**Subject:** 3/2025/0537 Root Farm Dunsop Bridge Clitheroe BB7 3BB

**Reference** 3/2025/0537

**Location** Root Farm Dunsop Bridge Clitheroe BB7 3BB

Proposal Change of use of remaining two traditional buildings at Root Farm to Class E

Client The Duchy of Lancaster			
Contract Root Farm Dunsop Bridge			
Drawing title RED LINE SITE BOUNDARY ON OS PLAN			
Scale 1:100	Job No. HB105	Drg No. D/CB	07A

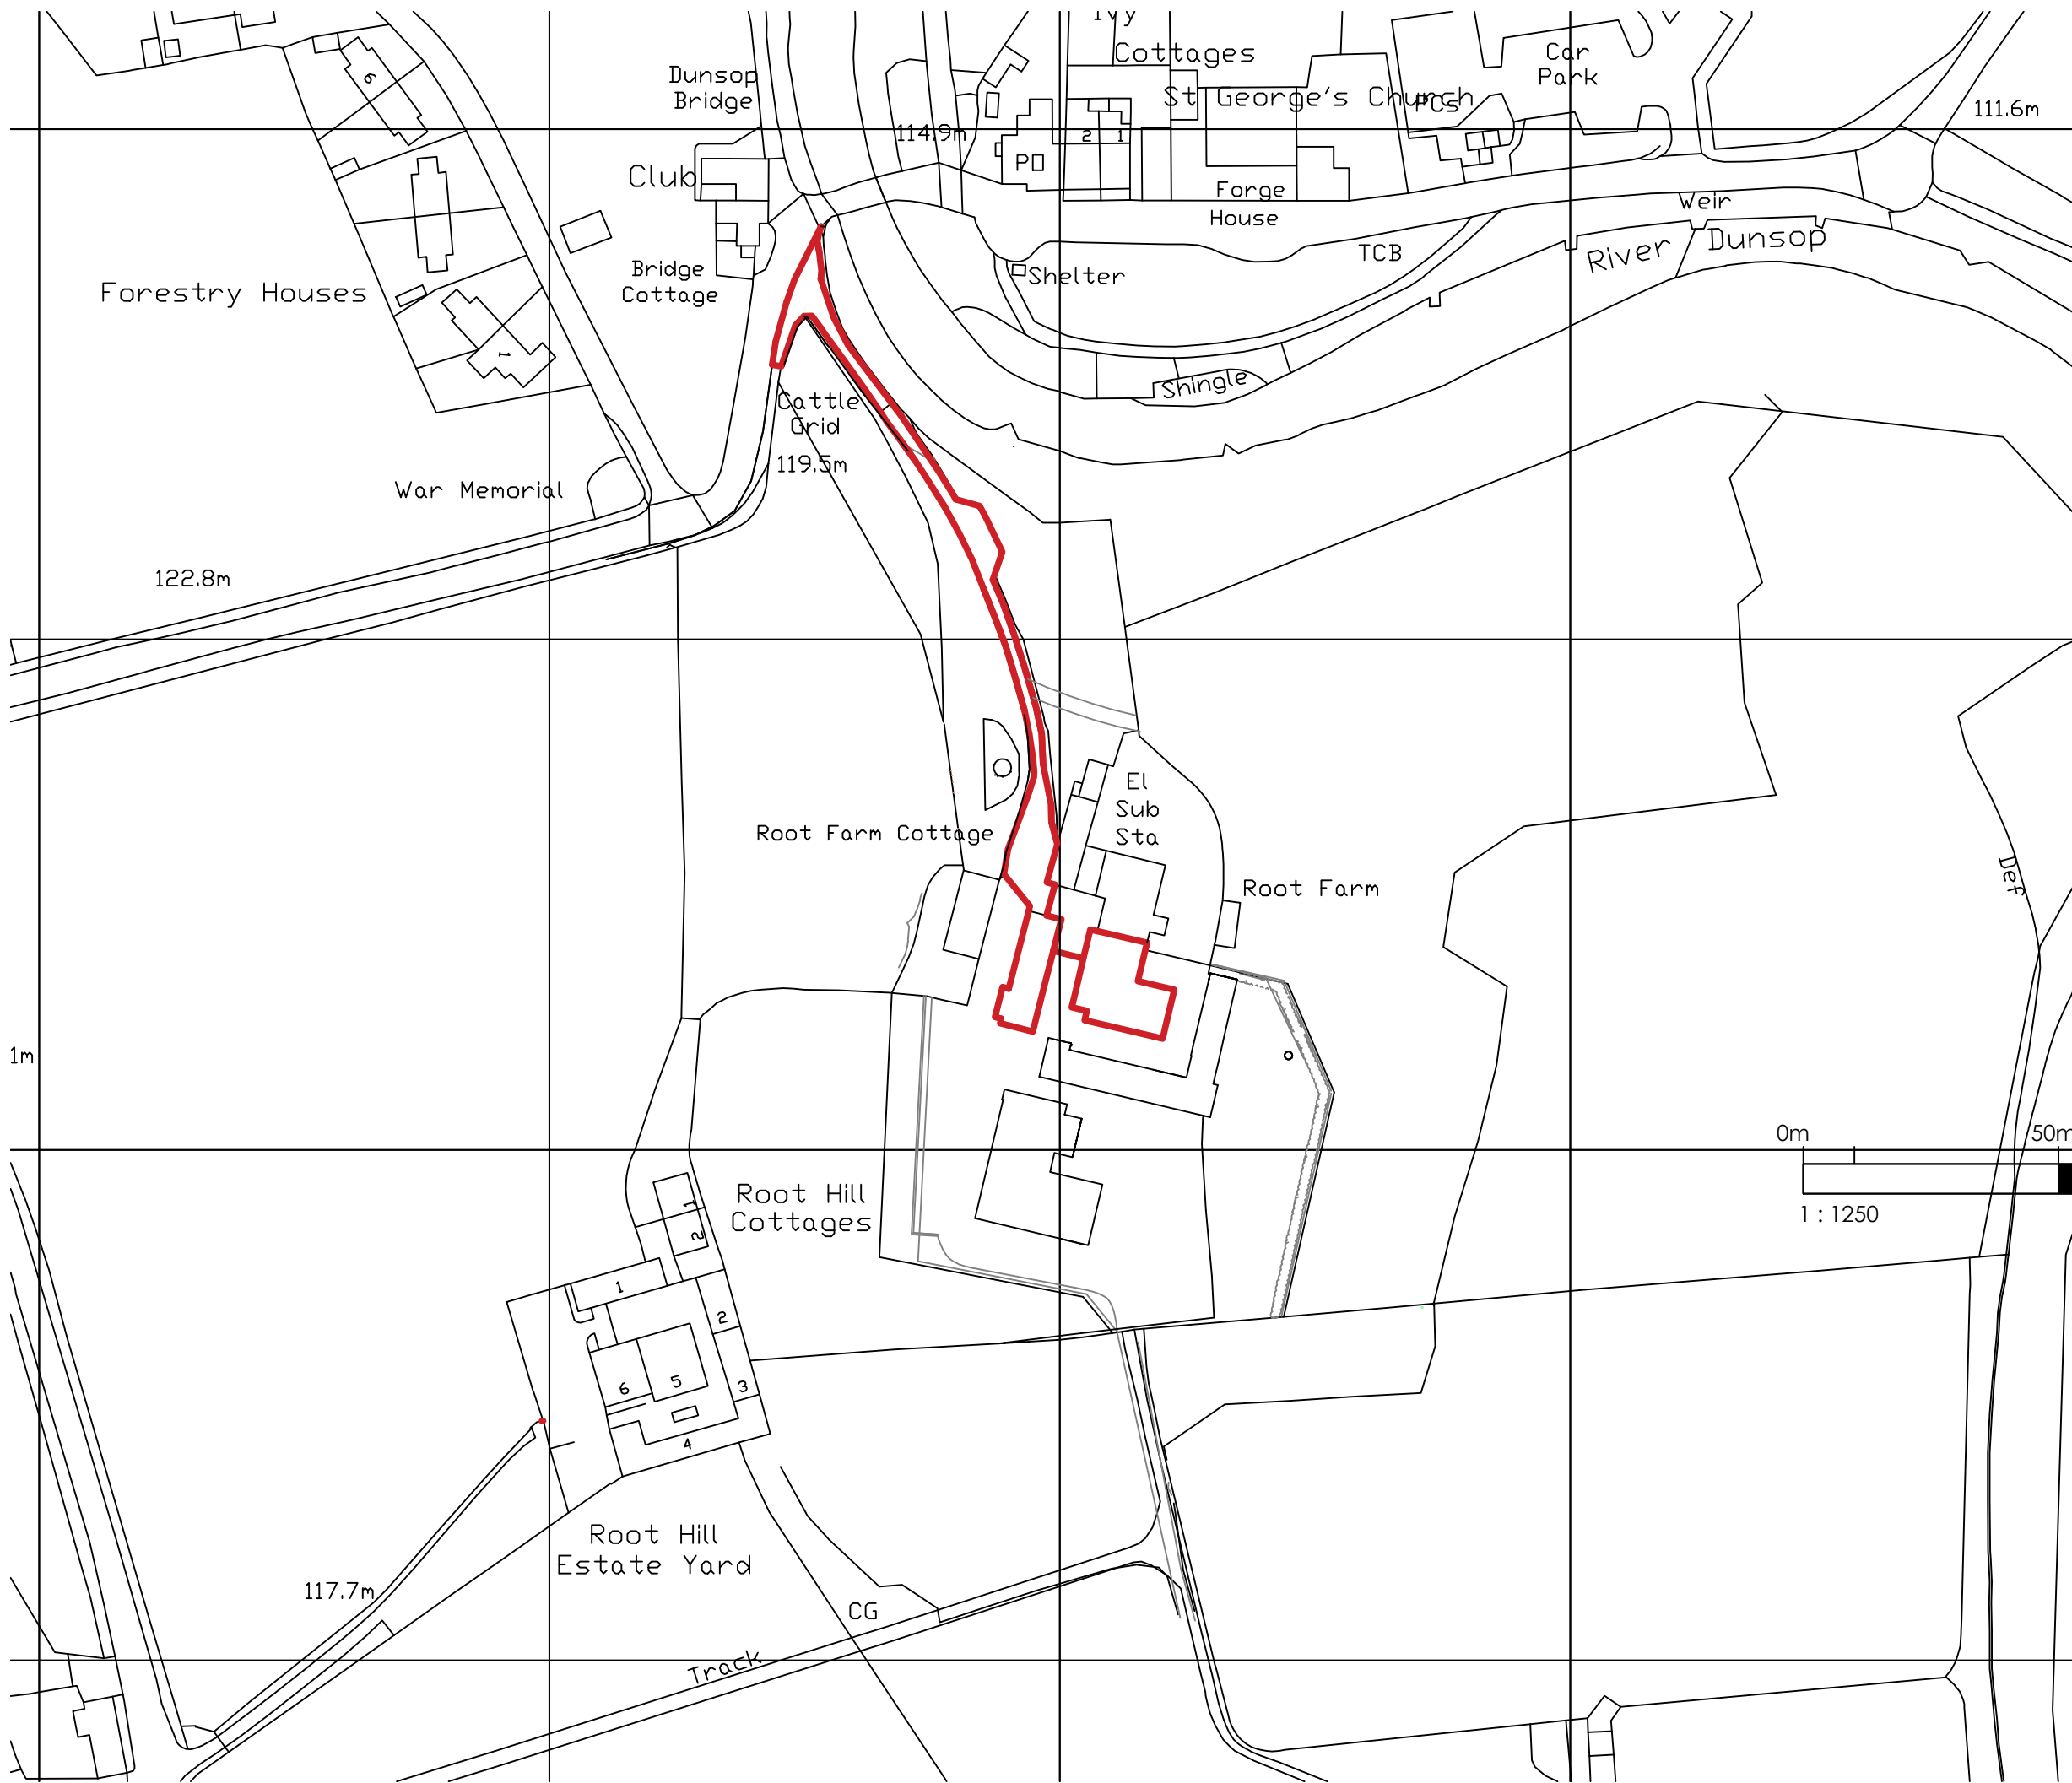
Footpath FP0308019 is recorded as running along the access track to the proposed development, as shown by the indicative line on the attached overlay. The Public Right of Way team is responsible for the surface being in a condition that is safe and fit for pedestrians, it does not maintain the route to a standard that is appropriate for vehicle use, nor does the Lancashire County Council Public Right of Way team wish to see the route deteriorate because of an increase in vehicle usage.

The Lancashire County Council Public Rights of Way team have no record of any public vehicular rights along FP0308019. The applicant should be certain that they have private vehicular rights along this public path before driving on it either during construction or for subsequent access. Without private vehicular rights or permission from the owner it is a criminal offence to drive a motor vehicle on the public path.

The infringement or obstruction of the existing public rights would be a criminal offence and one that would be subject to enforcement should it be impeded. To prevent this from occurring the right of way should always remain clear, not to be excavated nor used to park or store materials, vehicles or machinery.

Any changes in ground level or installation of drainage should ensure that surface water is not discharged onto the public right of way either within the proposed development site or in close proximity – this is to ensure public rights of way are not exposed to potential flooding or future maintenance issues.

Any trees or bushes should to be at least 3 metres away from a public right of way to prevent any health and safety issues and potential maintenance issues e.g. Overhanging branches or roots coming through the surface of the footpath concerned either within the proposed development or in close proximity.
